**From:** [Aaron Lowe](#)  
**To:** [Jamey Ayling](#)  
**Cc:** [Dan Young](#)  
**Subject:** Fowler Creek Camp Area  
**Date:** Friday, July 19, 2024 4:20:28 PM

Good afternoon Jamey, here are KCFD7 inputs for the Fowler Creek Project. Have a great weekend!

PROPOSED EMERGENCY INGRESS & EGRESS PLAN MAP - FOWLER CREEK GUEST RANCH

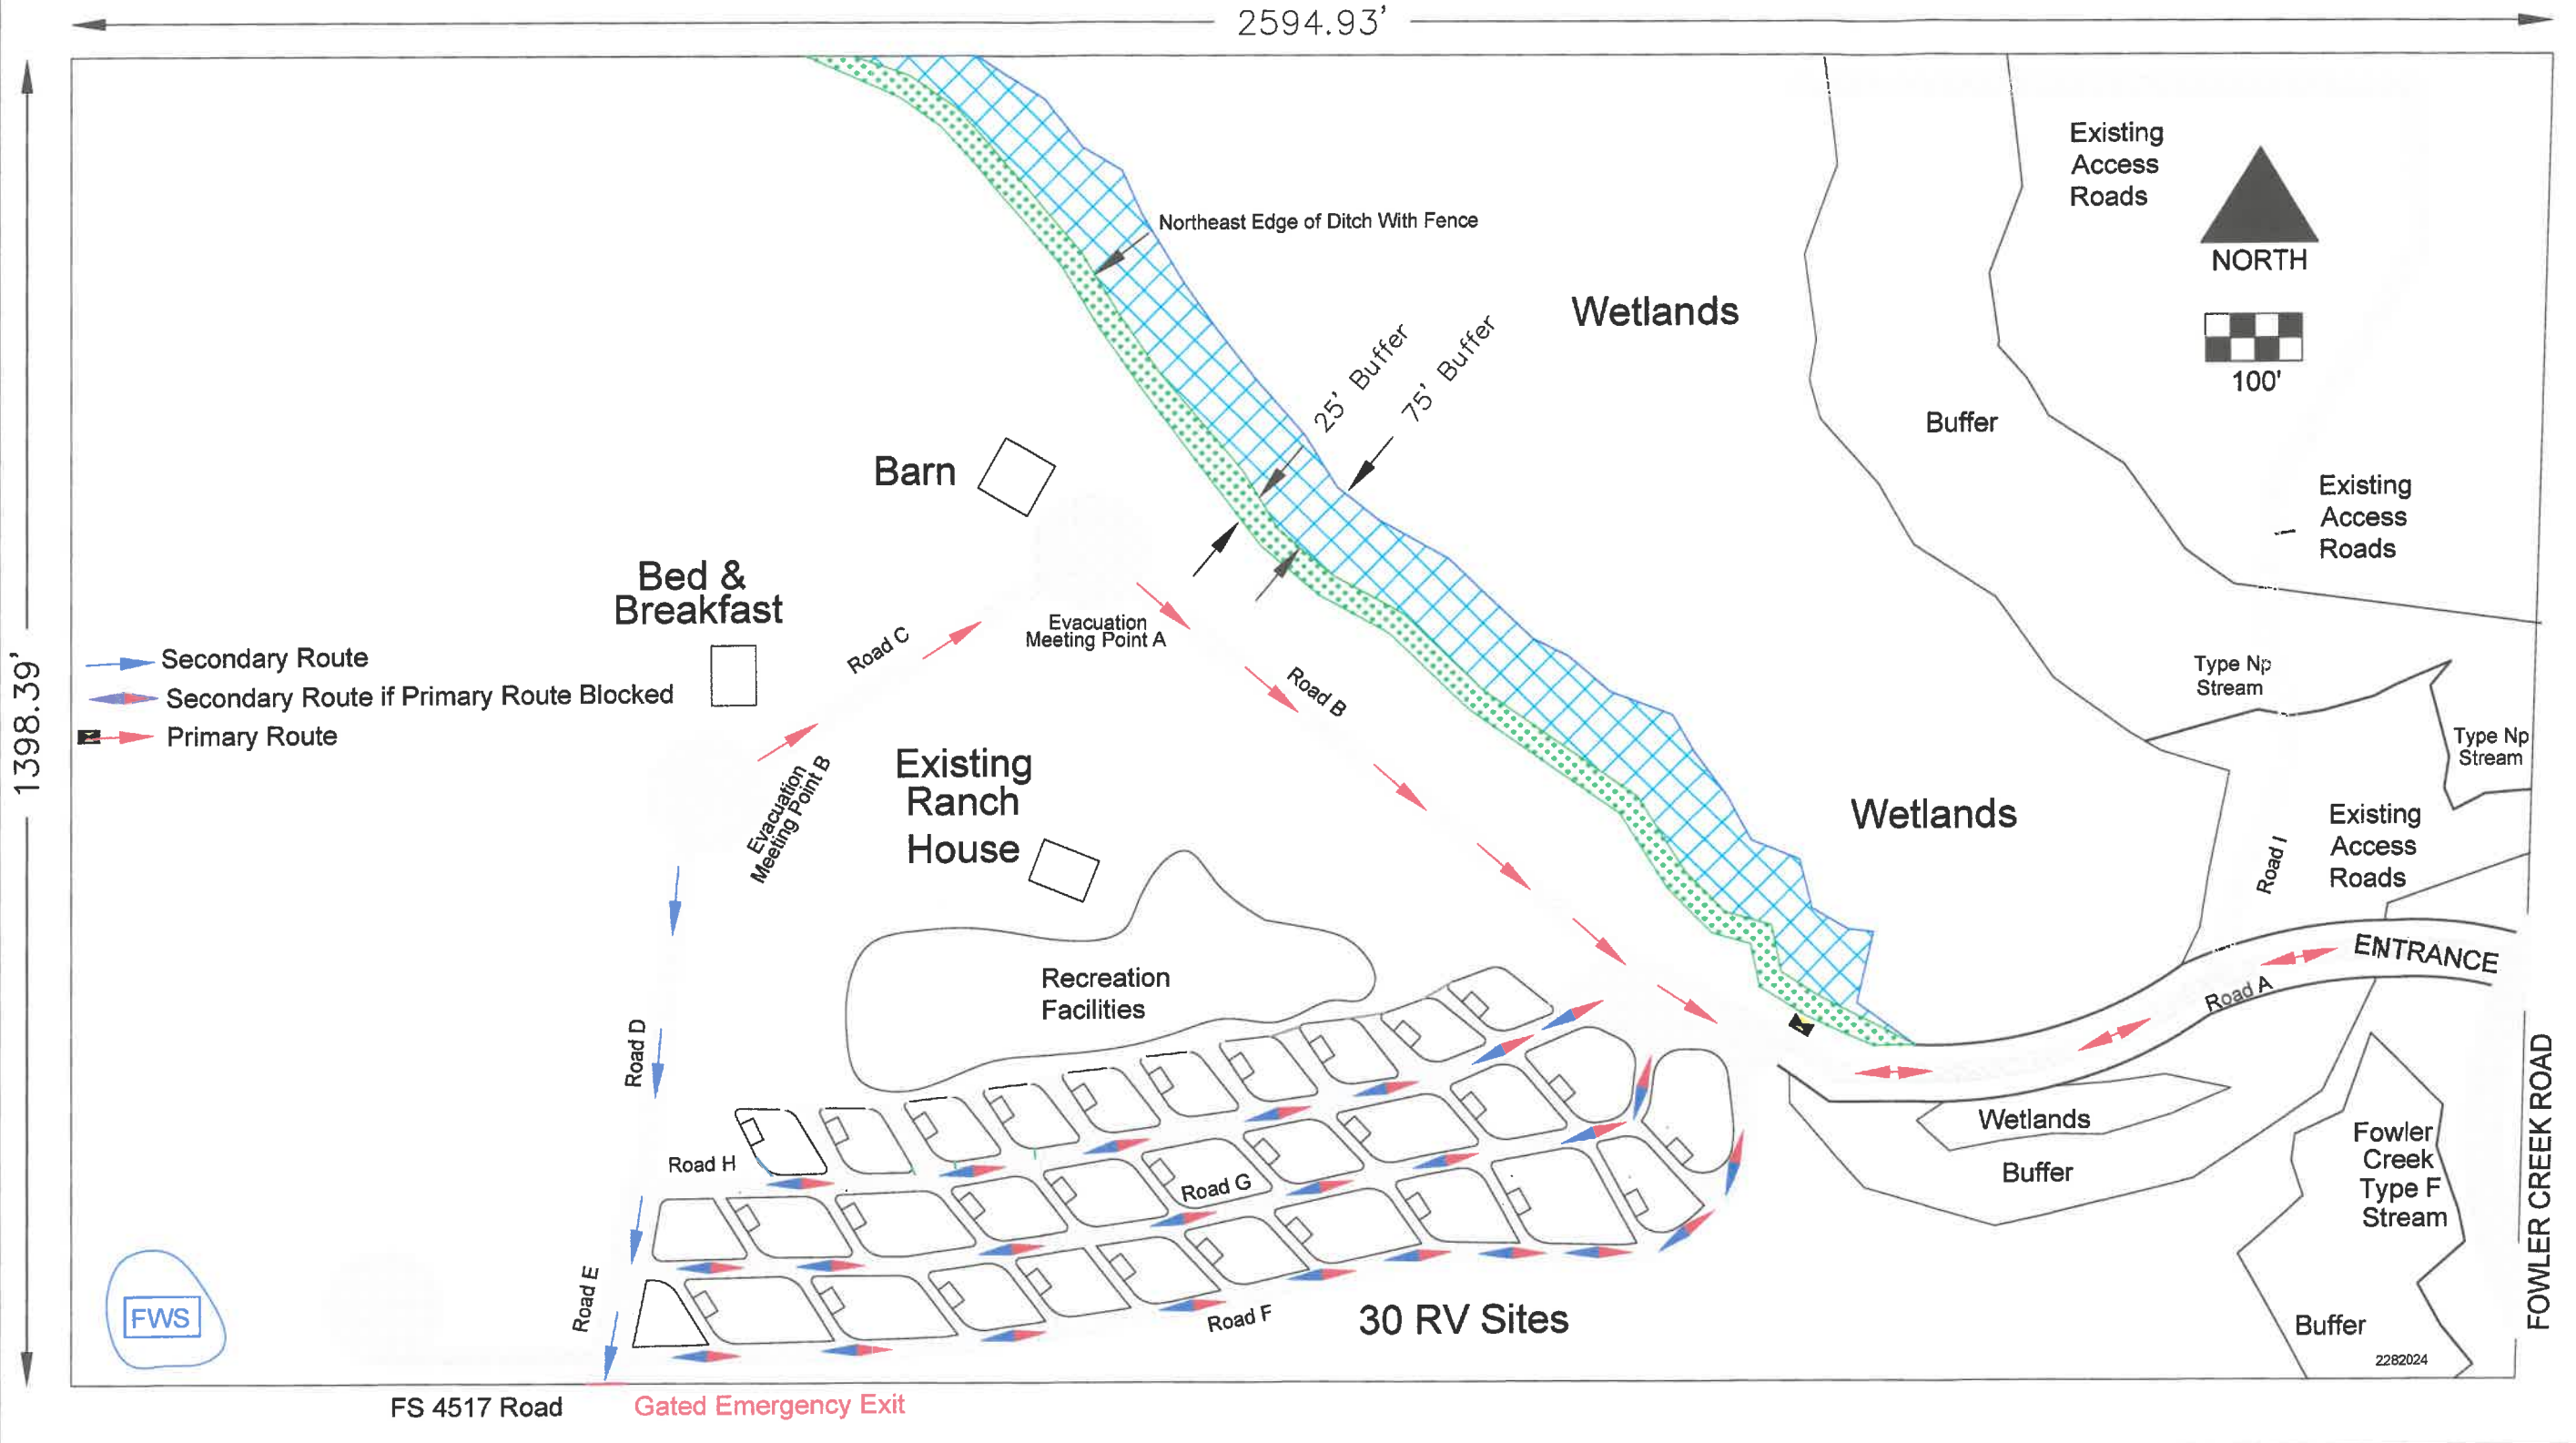
- Road width and construction needs to meet code
  - This includes USFS roads
  - Roads should be maintained (certified?)
  - Interior roads and turnarounds to meet Fire and WUI Codes
- Water source needs to meet code with each construction phase
  - Water Storage
  - Pressure
  - GPM
  - Fire Pump
- Fire Management Plan
  - Evacuation routes identified to those in attendance
  - Trailers are not to be towed during evacuation
  - Method for 24-hour seven day a week plan to open evacuation route gate
    - Southern Exit on FS4517
  - Trailer Sites properly marked individually
